Engineers comments;

NOTIFICATION FROM ARUN DISTRICT COUNCIL
Town & Country Planning Act 1990 (as amended)
Town and Country Planning (Development Management Procedure) (England) Order 2015
Planning Permission
APPLICATION NO: BN/18/20/PL
Registered: 19th February
2020

Site Address: Former Brooks Nursery Eastergate

Description of Works: Variation of condition 15 imposed under EG/29/13/ relating to condition 15-to change the foul drainage scheme from Sewage Treatment Plant to Pumping Station with associated drainage works.

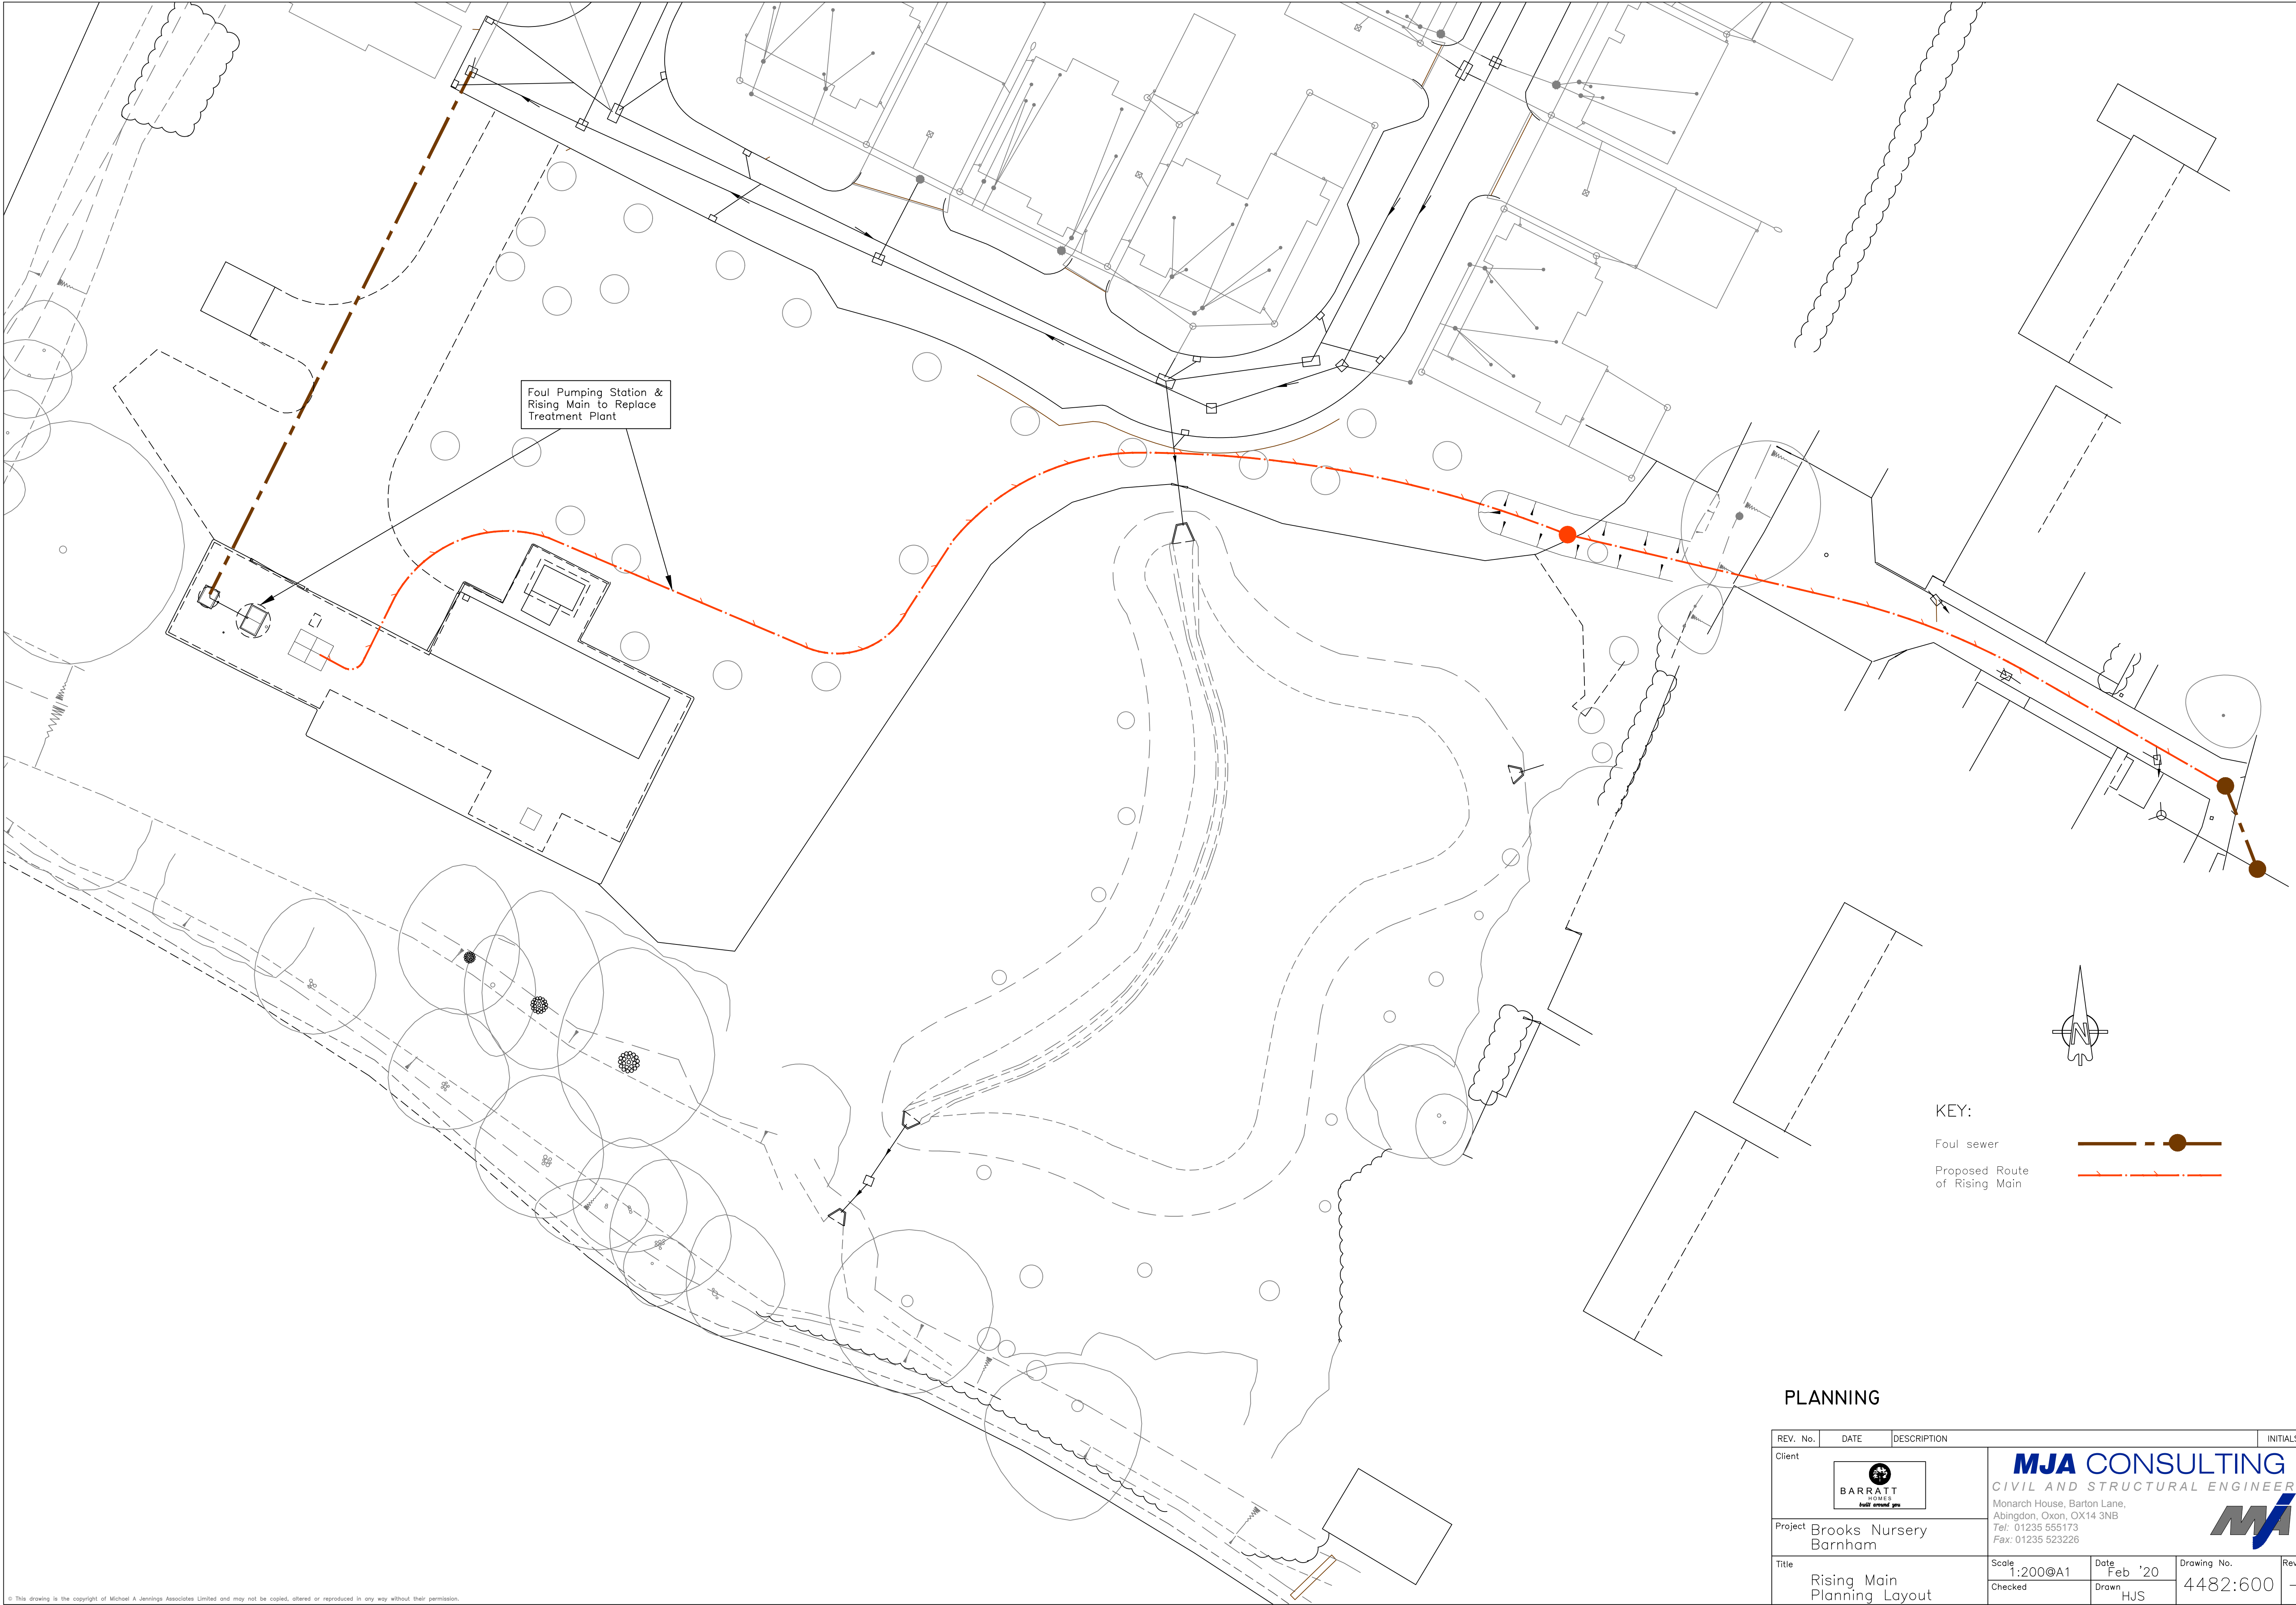
- b) Where the proposed rising crosses the incoming surface water outfall to the pond and the known land drain running parallel to the eastern boundary of the development, the applicant should provide a longitudinal section to prove no impact on these pipelines.
